From: Anita Gardner
Sent: 08 February 2013 10:11
To: Planning.Responses
Subject: FW: EP/129/12/DOC Discharge of condition 9 of EP/21/10 - Nursery Close, East Preston, West Sussex, BN16 1QD

From: Ian Brewster
Sent: 08 February 2013 10:08
To: Anita Gardner
Subject: RE: EP/129/12/DOC Discharge of condition 9 of EP/21/10 - Nursery Close, East Preston, West Sussex, BN16 1QD

Having discussed the landscaping specification with Ian Brewster, please see the attached amended landscaping plan and schedule (revision C) for your consideration.

Drawing Title
Landscaping Plan

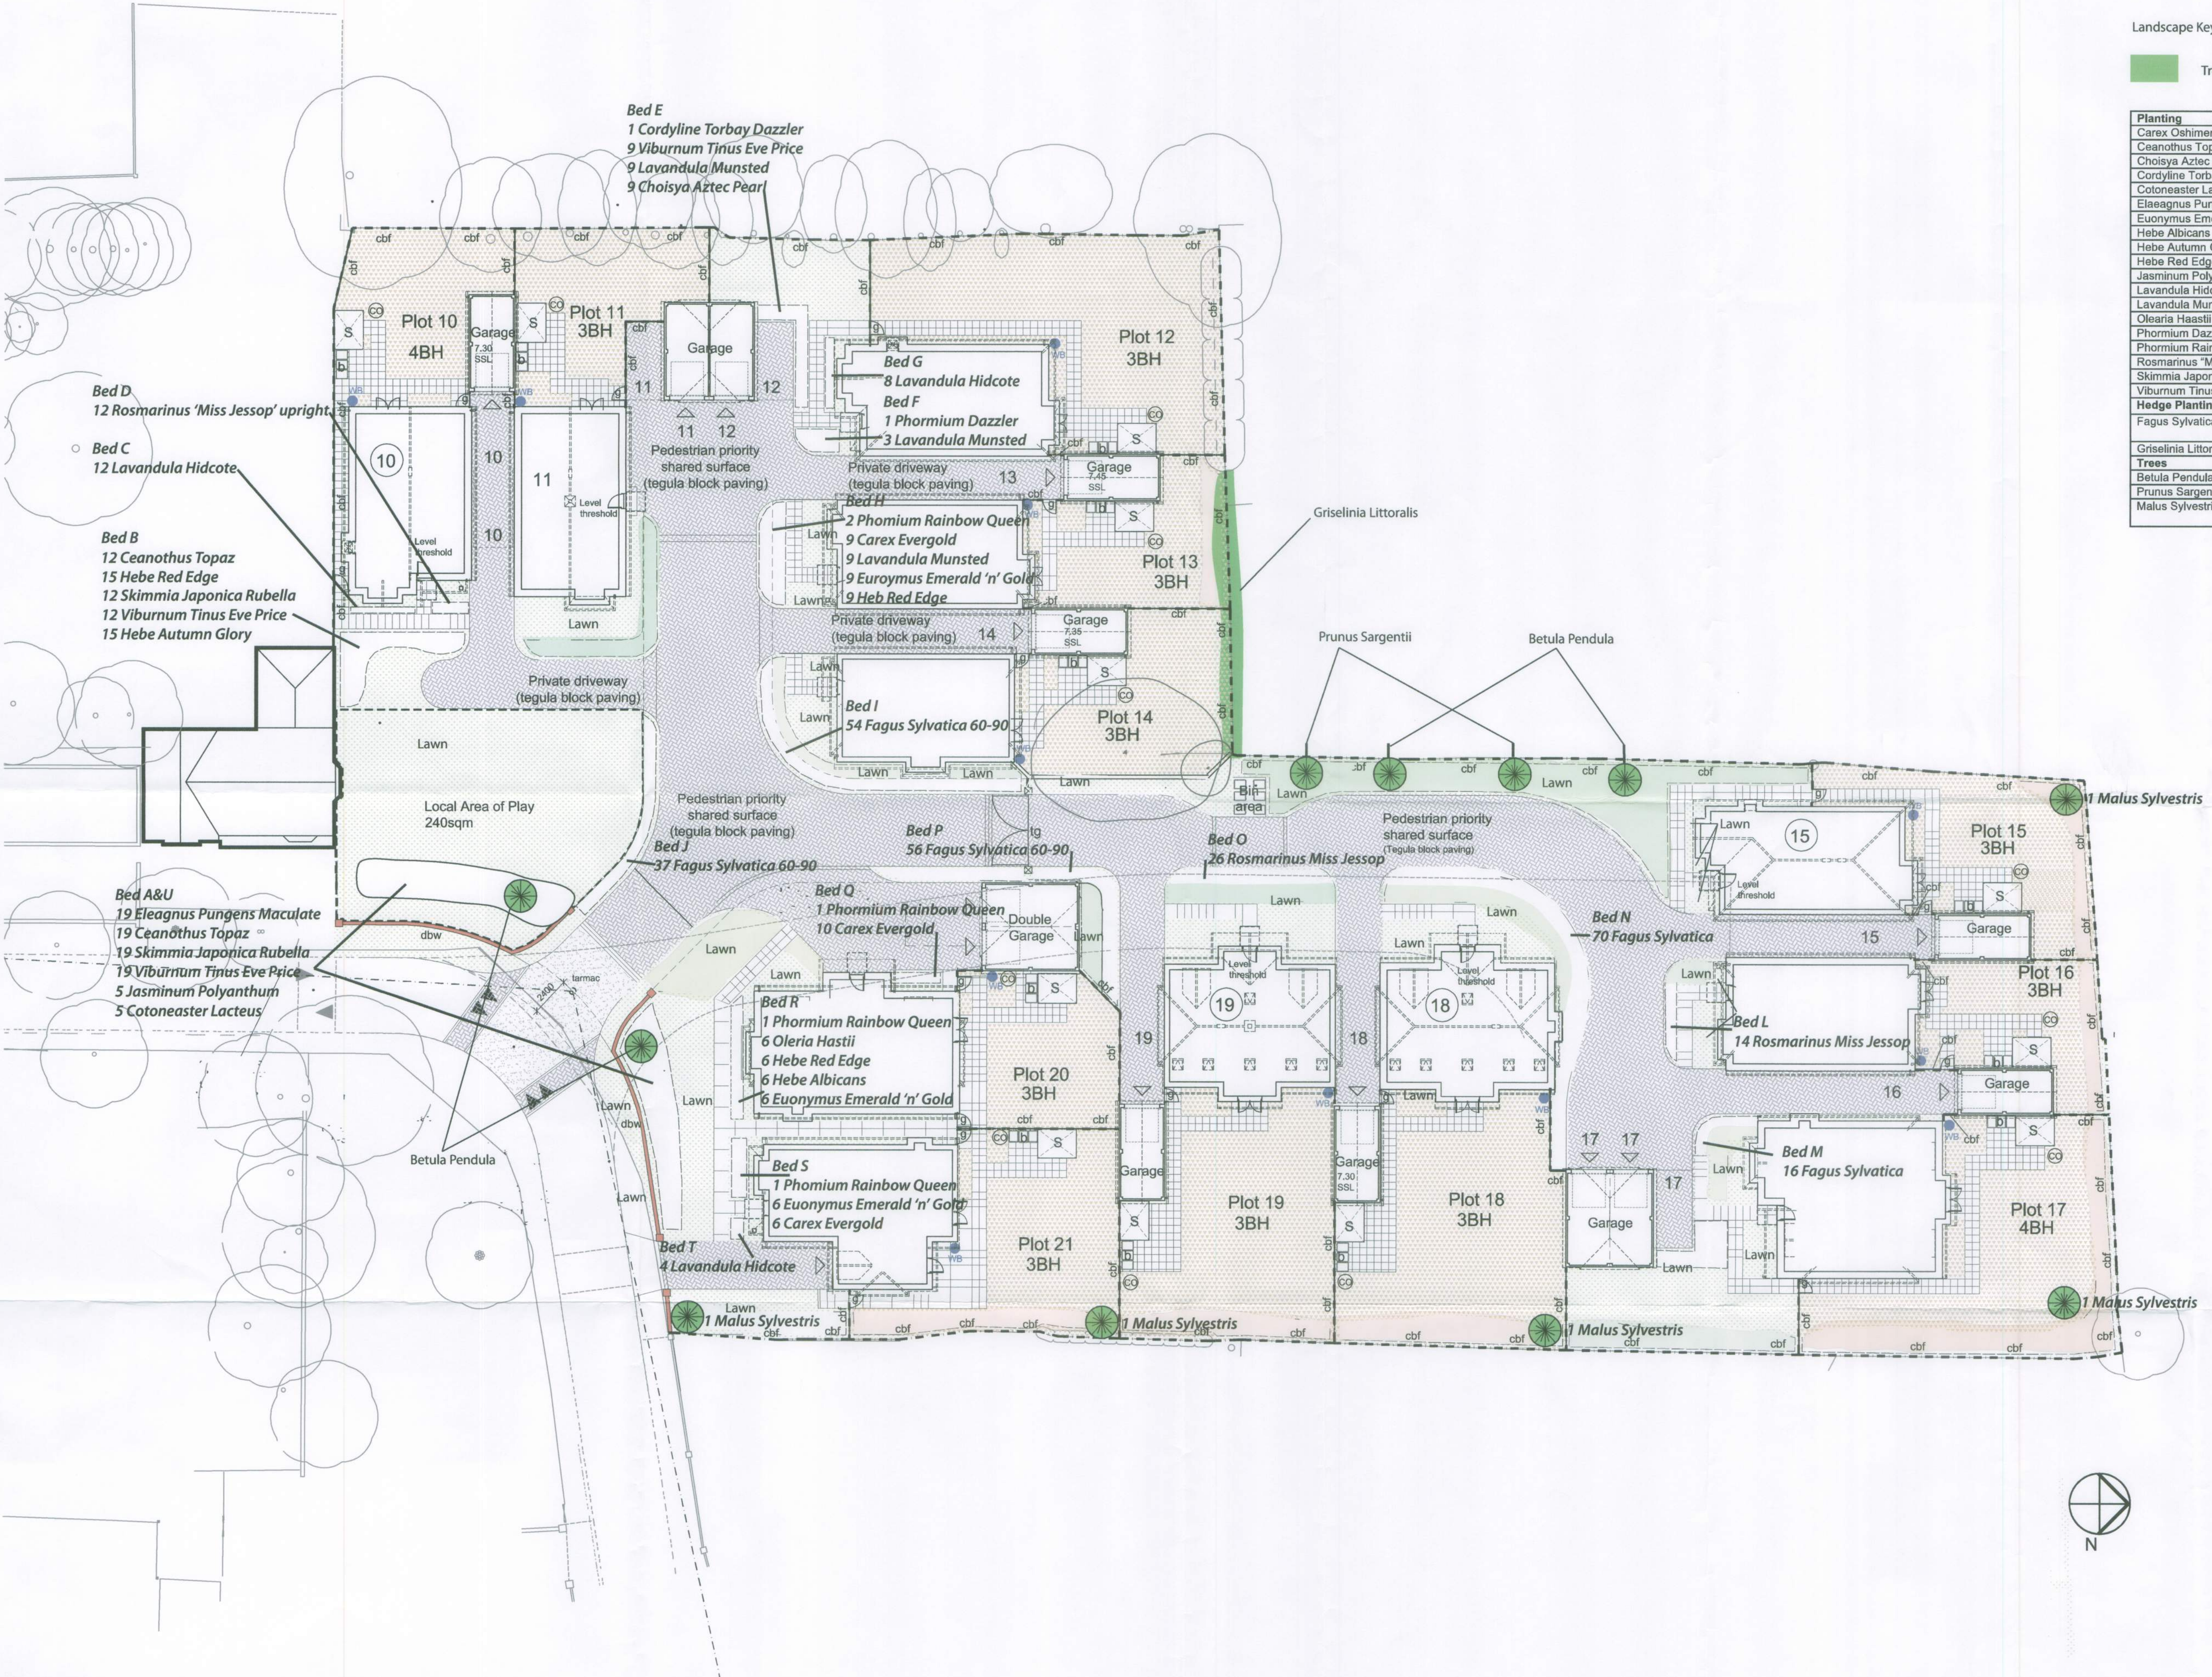
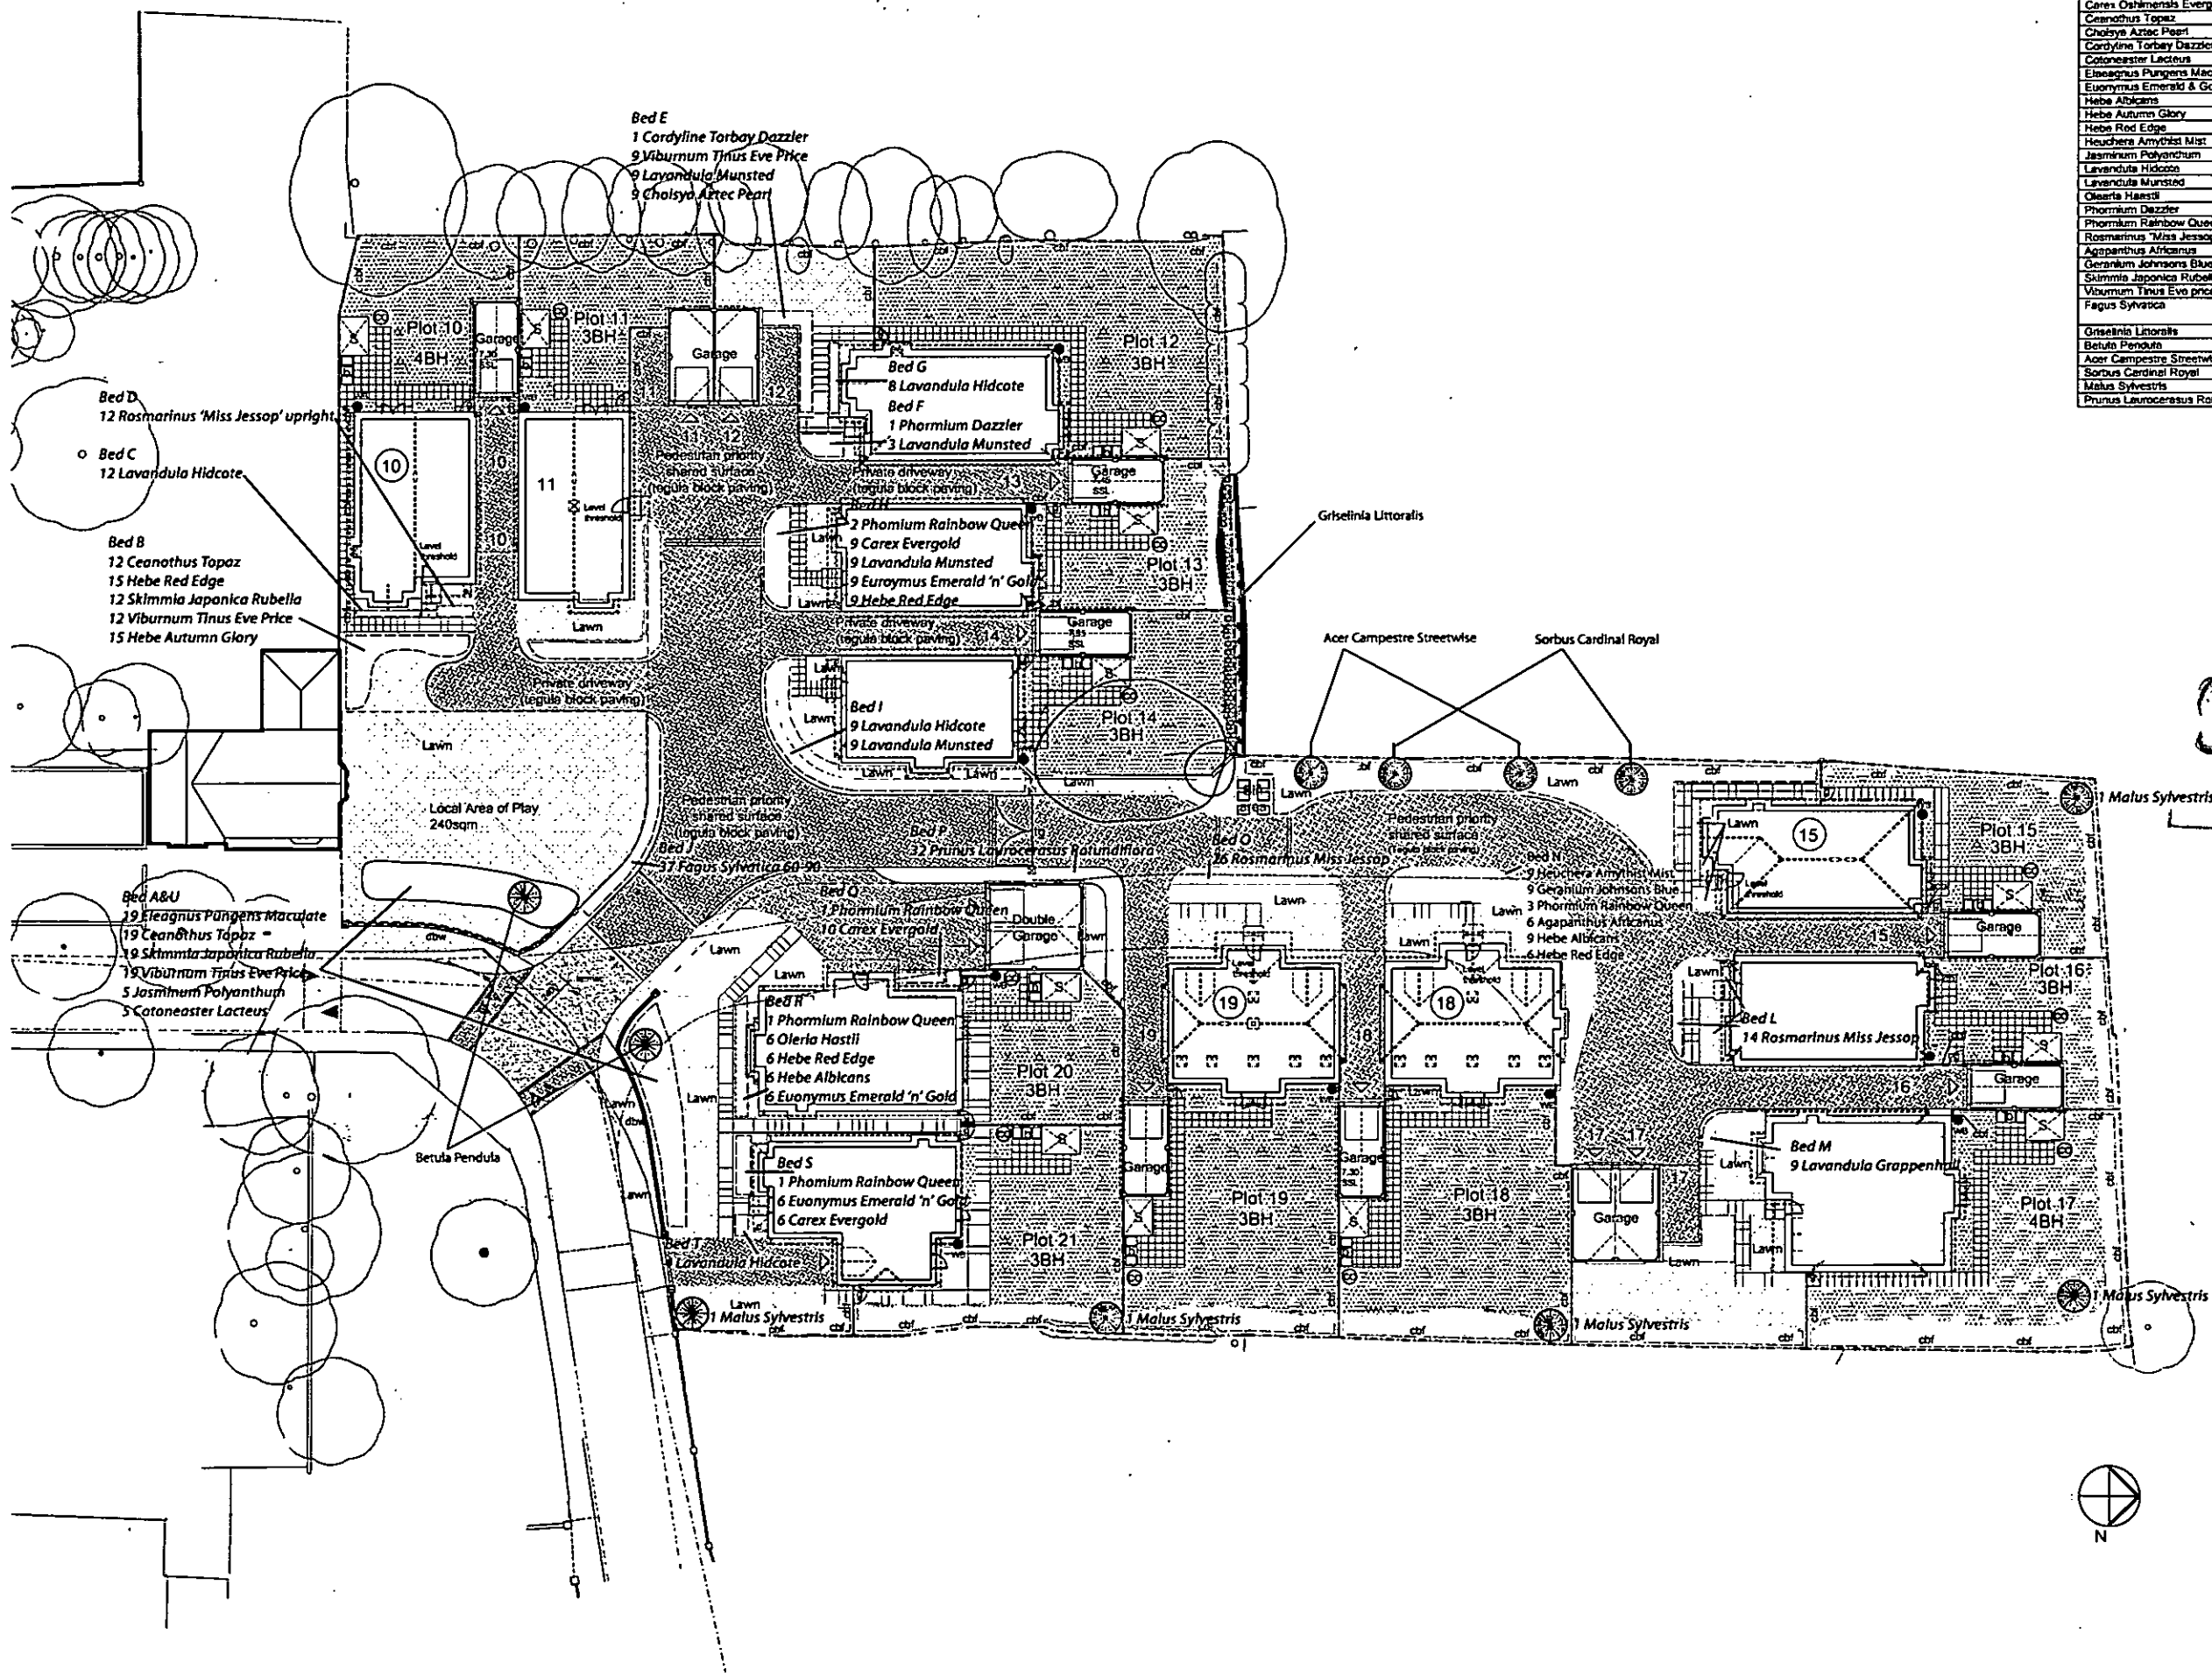
The tree appears to be narrow in crown form but possibly grafted to a wild stock that can become problematic due to pronounced surface root nuisance and with it planted within such a narrow space may be problematic for those which manage the site in the future.

Is the issue of Beech trees planted within a few metres of property to be resolved? The link below shows a typical mature Beech with its spreading roots and branches.

Thank you for submitting your landscape proposal. With regard to trees it would appear from the plan that you intend to plant Beech trees within a few metres of the development at plot 14, 17, 18 and 20 and pendulous Birch next to the highway. Is the choice of *Prunus sargentii* a fastigiated variety as otherwise it may conflict with their roots and branch growth interfering with traffic.

This is a good plan and acceptable to discharge Condition 9. I hadn't realised that the Beech referred to in the plan was to be a hedge and not planted as individual specimen trees. A Beech hedge would therefore have been fine.

I can, however, confirm that the Prunus Sargentii will be the 'Rancho' variety, which is a more columnar type with narrow growth, and should not affect the growth of adjacent trees.
